FW: Further plan review comments

**1 EGRESS AND FIRE RATING FIRST FLOOR PART PLAN WING A**  
SCALE: 1/8" = 1'-0"

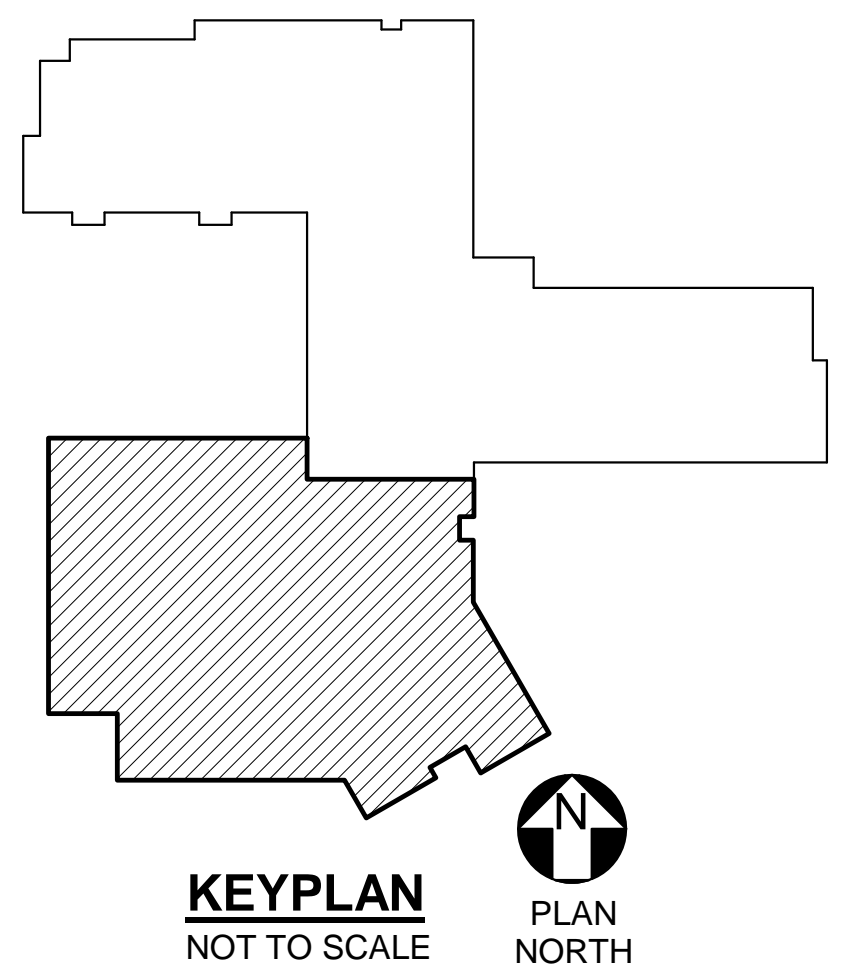
Below is the summary from Laura Clebak, our Fire Protection Engineer on the construction of the two hour firewall. Please let me know if this satisfies your question.

IBC lists a double fire wall per NFPA 221 as an acceptable method to achieve structural stability beginning in 2012 (Section 706.2 of both 2012 and 2015). The 2009 IBC, Table 706.4 with footnote a, requires the fire wall to have a 2-hour rating. IBC does not discuss how the 2-hour rating is to be achieved. It is also silent on how to approach the rating of a double fire wall. Therefore, we have reviewed the requirements of NFPA 221 which have more detailed requirements of double fire walls. Per the 2015 NFPA 221, Table 4.5, states that for a double wall assembly when each wall has a 1-hour rating, this is equivalent to a 2-hour single wall. We believe this could be considered as an alternative method under the 2009 IBC, Section 104.11 with the NFPA 221 Table as supporting documentation.
